RECEIVED
 MAR 03 2020
 Kittitas Co. CDS

A.	RELEVANT CODE SECTIONS	ANALYSIS	KC FDP FINDING Per FDP apprvl	Large Lot Plat response
	<p>Final Development Plan (KCC 17.36.040 Existing at the time of application)</p> <p>Following approval of the preliminary development plan by the county and before lot sales or building construction commences, the developer (owner) shall submit a final development plan for approval by the board of county commissioners which shall include all of the following:</p>			
A.1	<p>A staging plan describing the timing or sequence of construction for all the elements of the plan. Subdivision lot sales may precede other elements of the development upon final plat approval</p>	<p>Condition is addressed in Exhibit 2. The staging plan proposes a 20 year build out plan to accommodate delays outside of the applicant's control.</p>	<p>Satisfied</p>	<p>Satisfied</p>
A.2	<p>A map or maps of the site drawn at a scale no smaller than one hundred feet to one inch showing the following:</p>	<p>Exhibit 3, 4, and 5 submitted:</p>

<p>“Great care will be taken by the Dunford PUD in regards to the construction of the roads and infrastructure. Where practical all utilities will b

Revised Dunford P.U.D.
Final Development Plan Map
Submitted Date: 5-12-2019

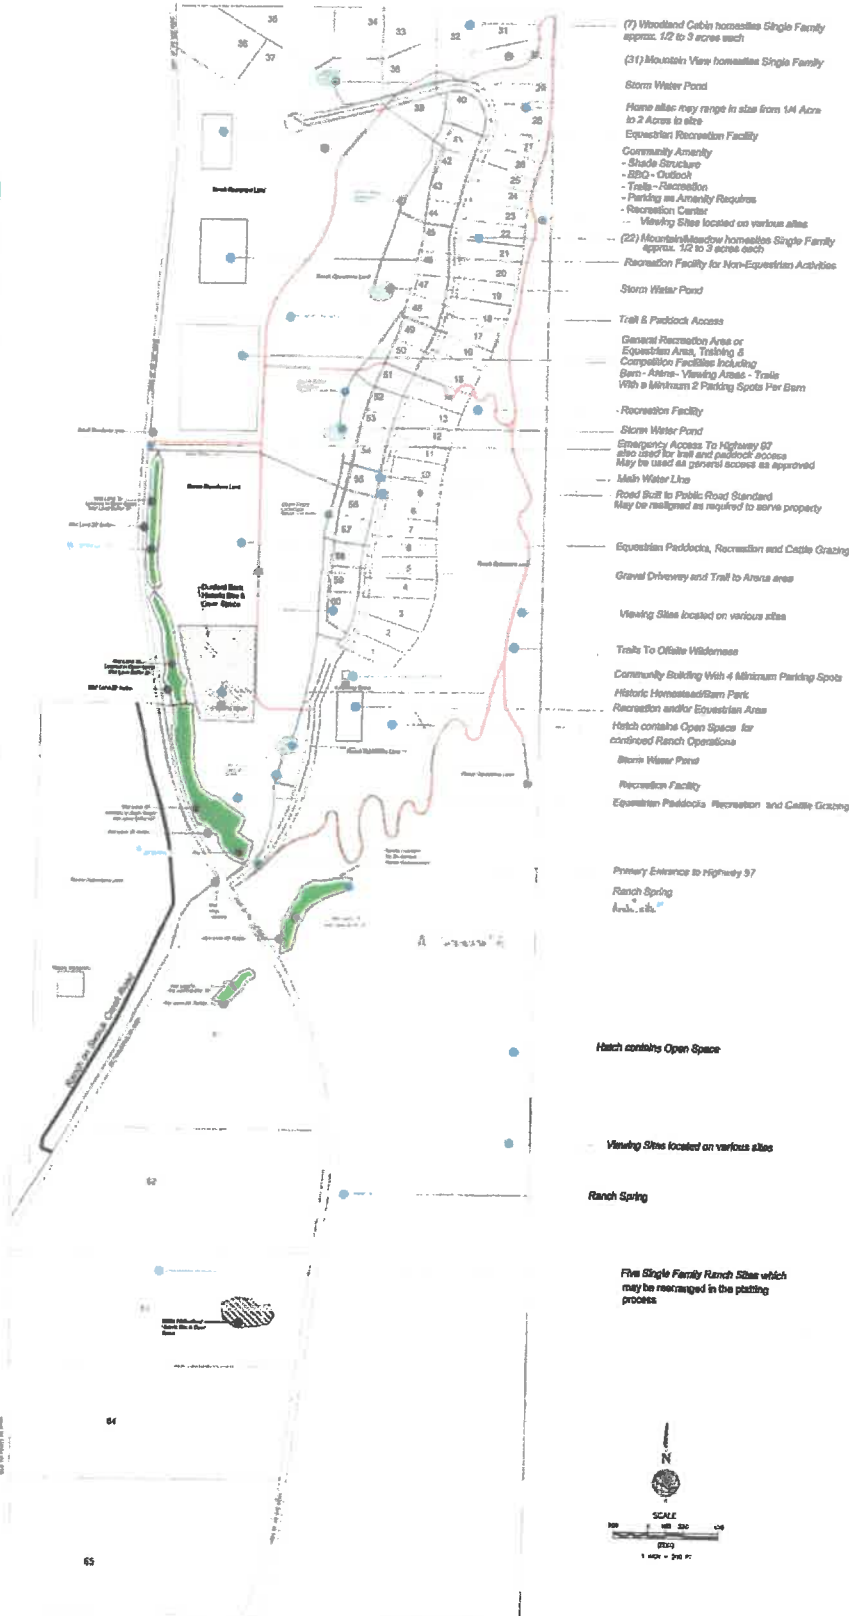
<p>i. Preliminary engineering plans including site grading, road improvements, drainage and public utilities extensions;</p>	<p>i- Site plan (exhibit 3) demonstrates basic road layout and access to Highway 97, including emergency access. The applicant states that road places, site grading, road improvements and drainage will be submitted at the final platting stage. Utilities and septic are stated as privately owned with setbacks indicated in exhibit 5.</p>	<p>i. Satisfied</p>	<p>i. Satisfied, as the large Lot subdivisions is served off of existing county roads. Engineering plans, grading, improvements, drainage and public utilities will be address at the higher density final platting stage.</p>

<p>ii. Arrangement of all buildings which shall be identified by type;</p>	<p>ii- Exhibits 3 demonstrate the locations of all buildings and their associated use. Residential sites do not indicate specific types (SF, MF, condo, etc.) 65 residential units have been approved with 65 residential lots allotted despite type.</p>	<p>ii. Satisfied: Identified as single family residential</p>	<p>ii. Satisfied: Identified as single family residential</p>
<p>iii. Preliminary building plans including floor plans and exterior design and/or elevation views;</p>	<p>iii- The applicant states that the Dunford PUD will adopt by reference the preliminary building plans from Swank Creek and Evergreen Ridge PUDs. Single family residence plans exist on file with other approved final development plans (RZ-01-00010 Evergreen Ridge & RZ-06-00027 Ranch on Swank Creek), and it is unnecessary for applicant to provide sample plans of condominiums.</p>	<p>iii. Satisfied</p>	<p>iii. Satisfied</p>

<p>viii. Proposed storm drainage plan;</p>	<p>viii- Exhibits 3 and 4 provide a conceptual layout of the stormwater management plan. The applicant states they will work with the Department of Ecology on a stormwater plan once approved. Stormwater plan will be submitted at final</p>	<p>viii. Satisfied</p>	<p>viii. Satisfied</p>

A.4	<p>Provisions to assure permanence and maintenance of common open spaces;</p>	<p>The applicant states that all common open spaces will remain in the ownership of the Ranch on Swauk Creek LLC ownership. This will need to be expressed as a plat note for final plat.</p>	<p>Satisfied: Note 4 on the Final Development Map expresses Ranch on Swauk Creek Ownership</p>	<p>Satisfied: Note 4 on the Final Development Map expresses Ranch on Swauk Creek Ownership</p>
A.5	<p>Statement of intent including estimated cost for landscaping and restoration of natural areas deposited by construction including tree planting.</p>	<p>All utilities when practical will be placed within the road ROW's. An estimated cost of \$5 per lineal foot of developed road is anticipated for restoration of areas distributed construction activities. (statement appears to be cut off) More information will be required</p>	<p>Satisfied: Updated narrative provided with landscape estimate.</p>	<p>Satisfied: Updated narrative provided with landscape estimate.</p>

B.23	<p><u>Open Space Tract Ownership and Maintenance:</u> Open space tracts shall be jointly owned and maintained by the developer, legally responsible owner, homeowner’s association or other legal entity made up of all benefited property owners.</p>	<p>Exhibits 3 and 4 indicate 2 primary areas of open space, one indicated in blue hatch and the other in yellow hatch. The applicant states that the difference between the two areas is that the blue hatch area is the area that will be directly owned and maintained by the Ranch on Swank LLC in perpetuity. As indicated in sections B6 and B12 of this matrix, some issues arise related to conditions with this distinction. These issues will need to be addressed before final platting.</p>	<p>Satisfied: Note 4 of Final Development Plan map</p>	<p>Satisfied: Note 4 of Final Development Plan map</p>
